PLANNING CONSULTATION RESPONSE

| Application No | 2025/0983 |
| Proposal | Change of use of the existing caretakers bungalow into a school day nursery (Use Class F1(a)) with associated alterations to external appearance; and works to wider school site including extension to car park, new external play areas and boundary treatments (Part Retrospective). |
| Address | The Mill Academy, Lobwood, Worsbrough Bridge, Barnsley, S70 5EP |

Onsite Habitats (areas in purple were cleared before site visit)

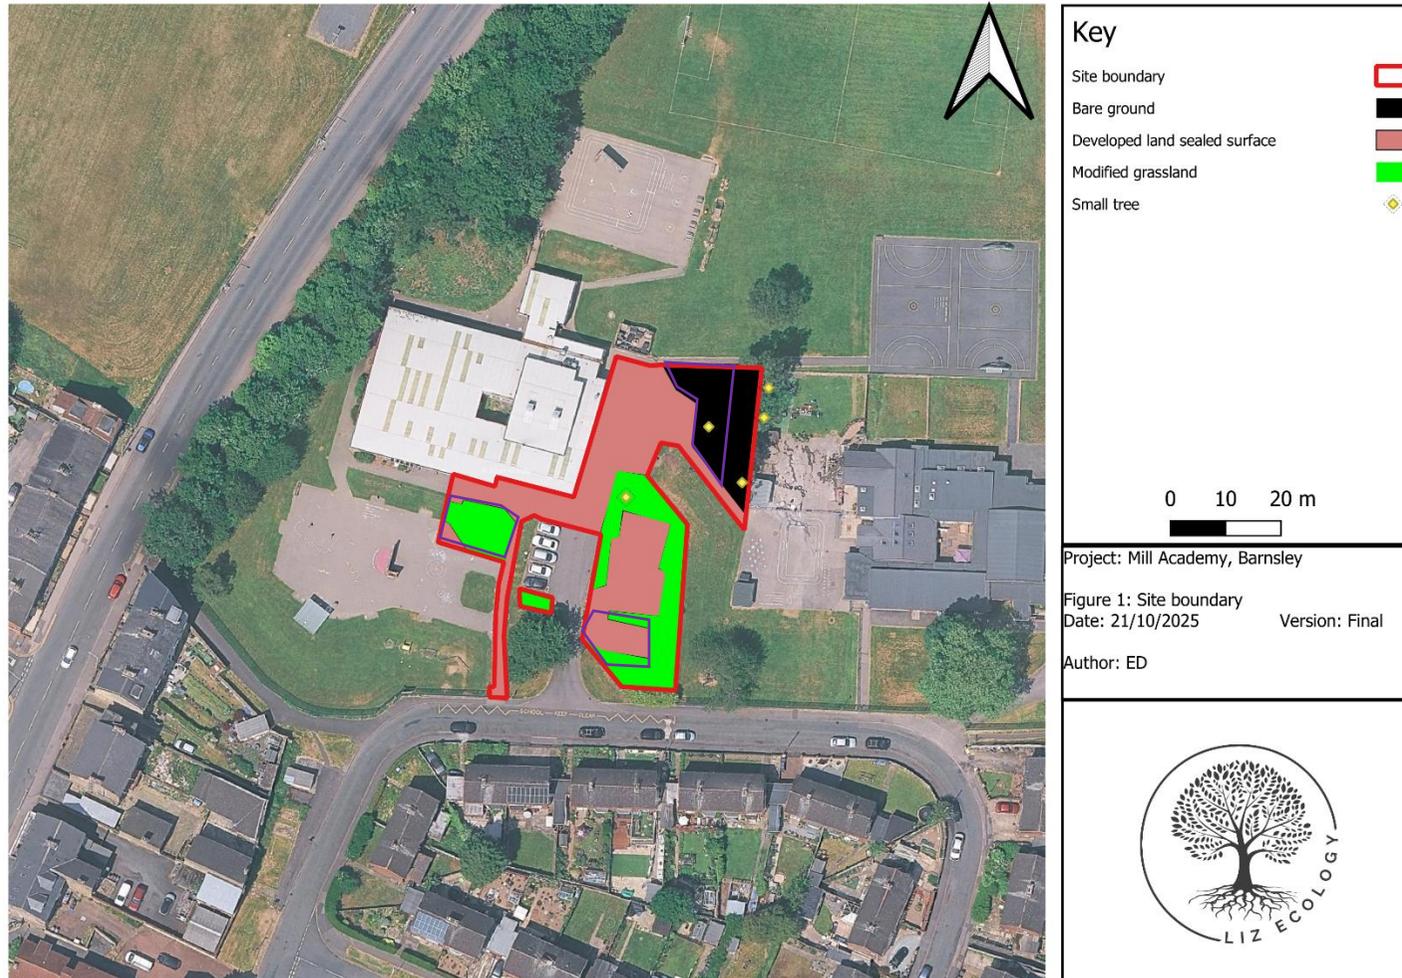
- It is not clear within the report which habitats were cleared prior to an assessment taking place, clarification is sought on this. The ecologist should note the degradation rules which apply to habitats cleared prior to an ecological assessment. All baseline habitats have been assessed as poor. Was there evidence on site to confirm this?
